Address: 100 Sheridan St.

Permit # 2014-0230

CHECK-LIST AGAINST ZONING ORDINANCE

Proposed Use/Work - build a detached single family home ^{Residential condo} on existing lot w/ existing two family

A100

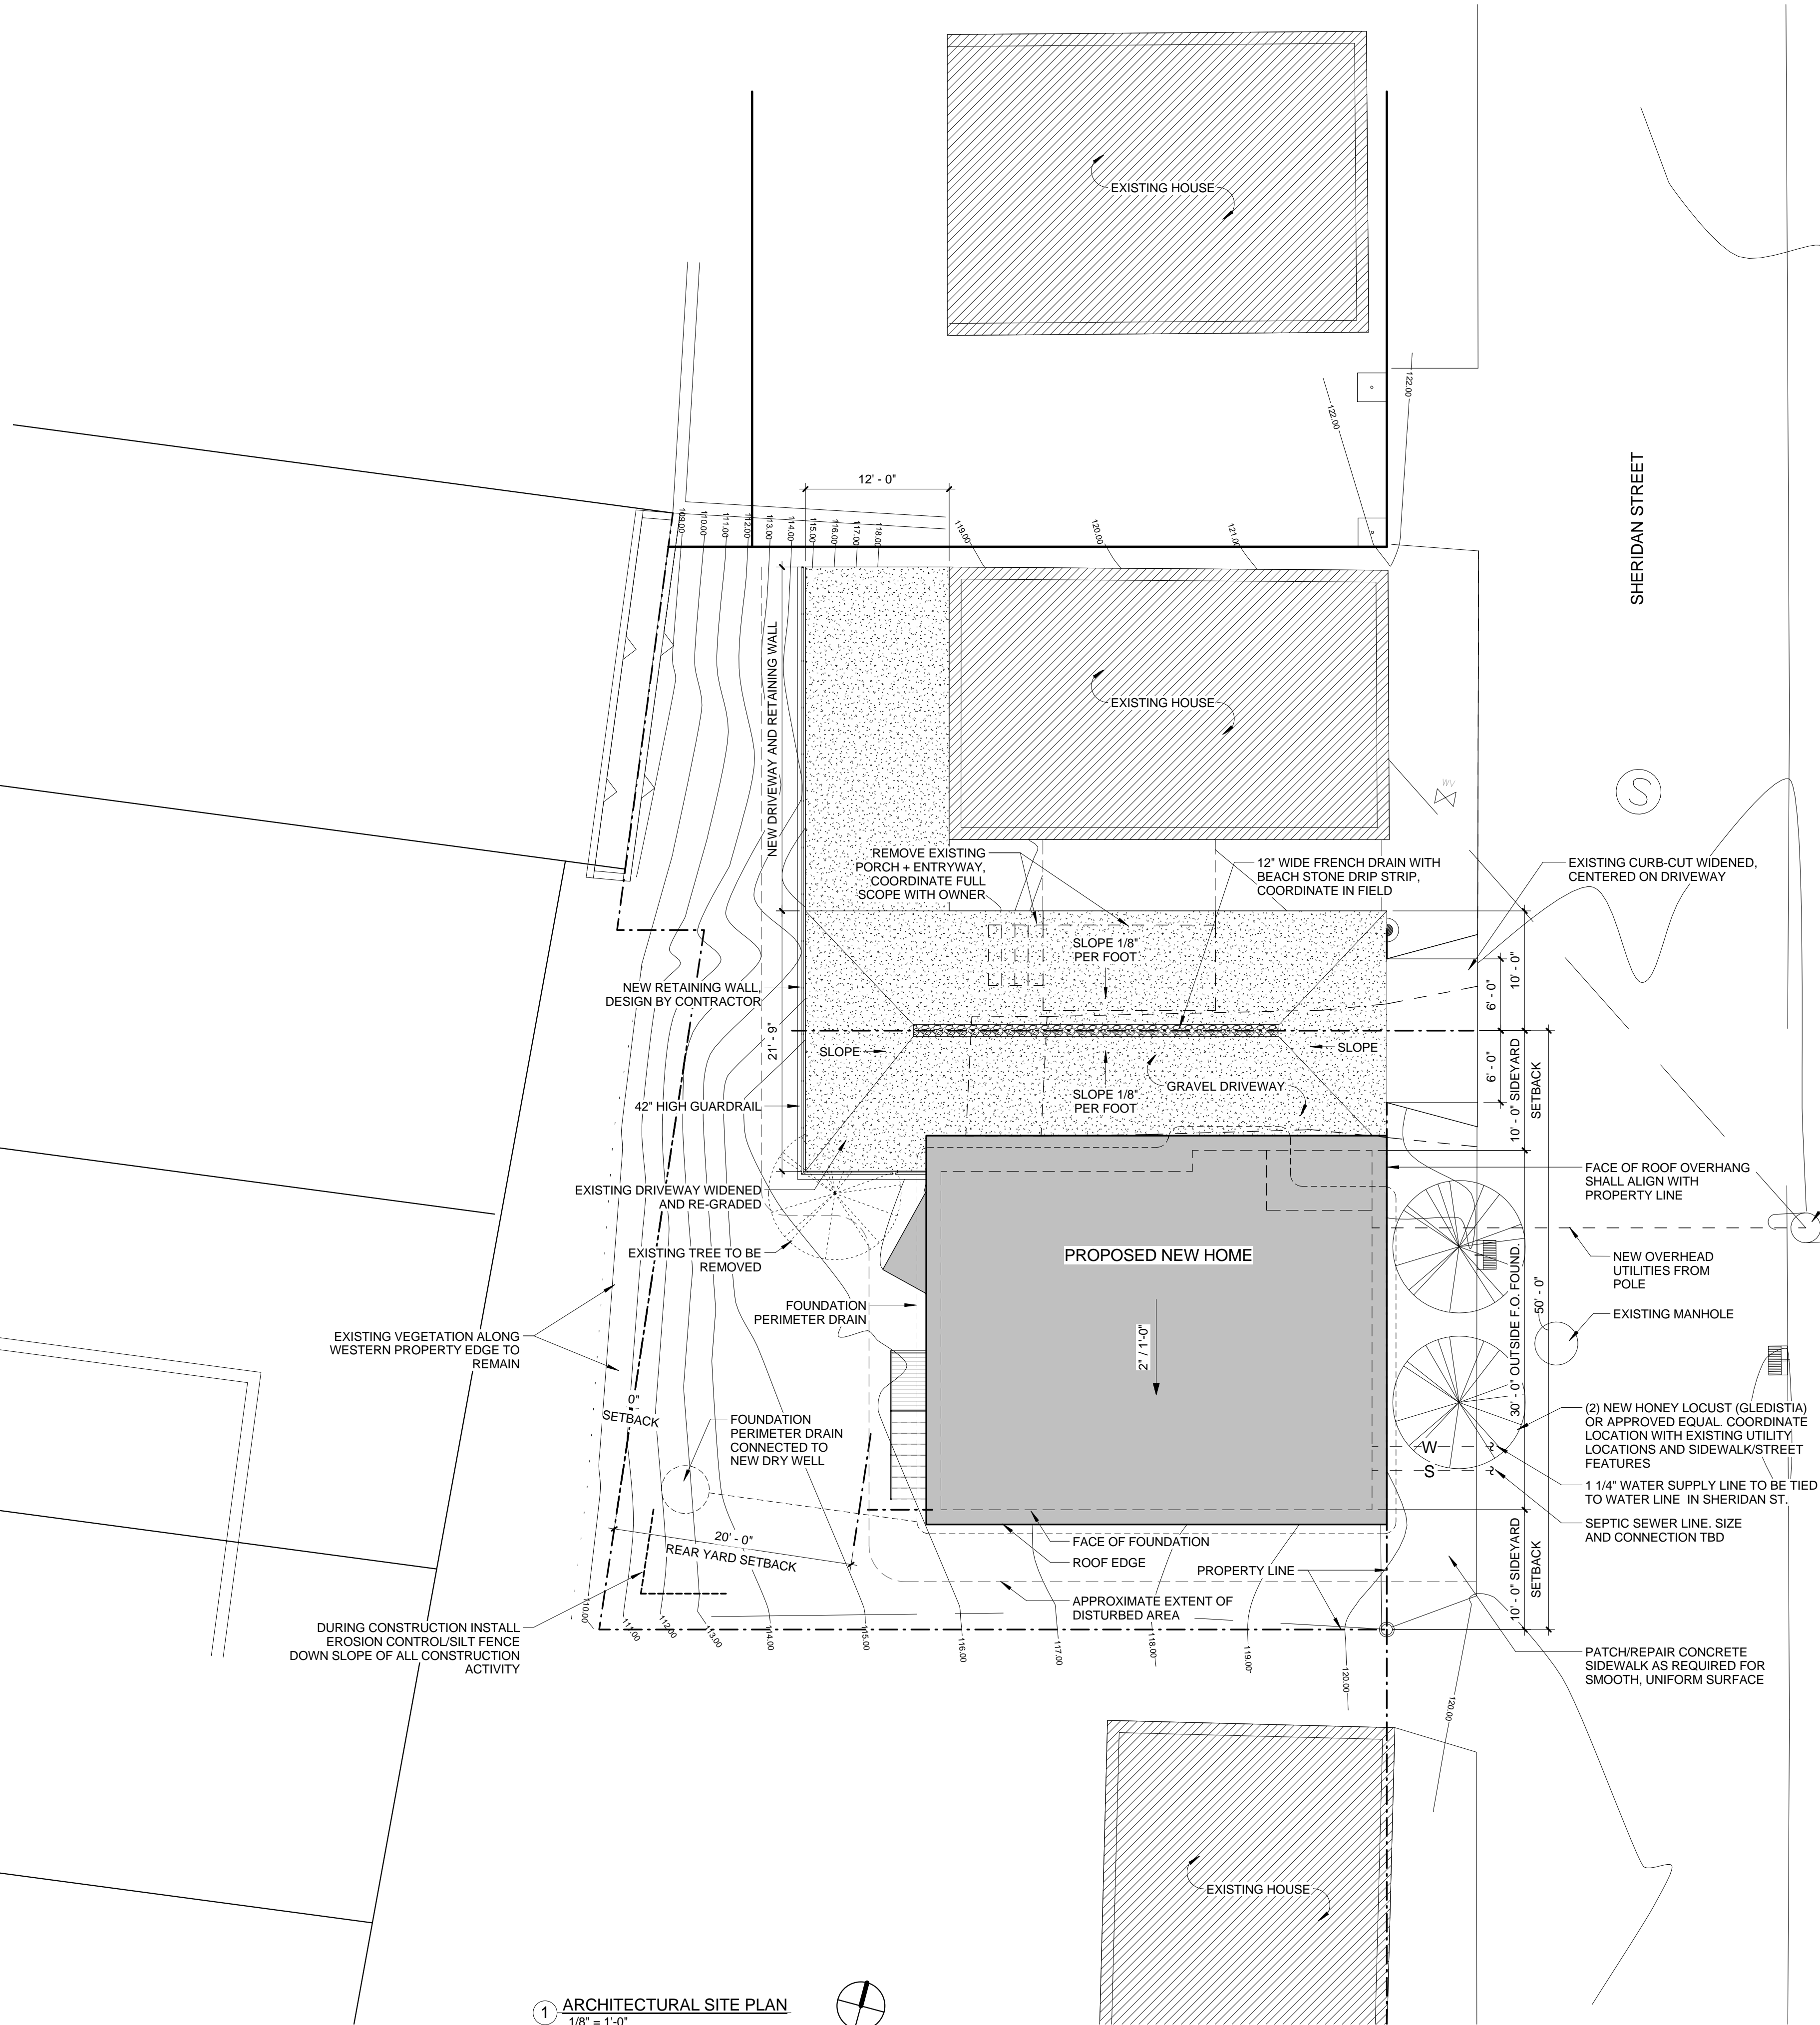
* Front Yard - 10' or average - ^{0'} boundary survey shows 62' Sheridan 106' Sheridan ^{20'} ~~to front~~ ^{off} centerline (OK)

* Rear Yard - 20' min - 20.9 b rear deck, 15' b 2nd floor angled bumpout

Side Yard - ^{3 stories} 10' min - 10.06 scaled on left - ~~15' min~~ (OK)
4 stories is 12'

Projections - landing steps 4.3 x 12.4

Width of Lot - 40' min - 90.2 scaled (OK)

Height - 45' max - 41.6' to highest point from lowest grade

Lot Coverage Impervious Surface - 50% = 2781 sq ft
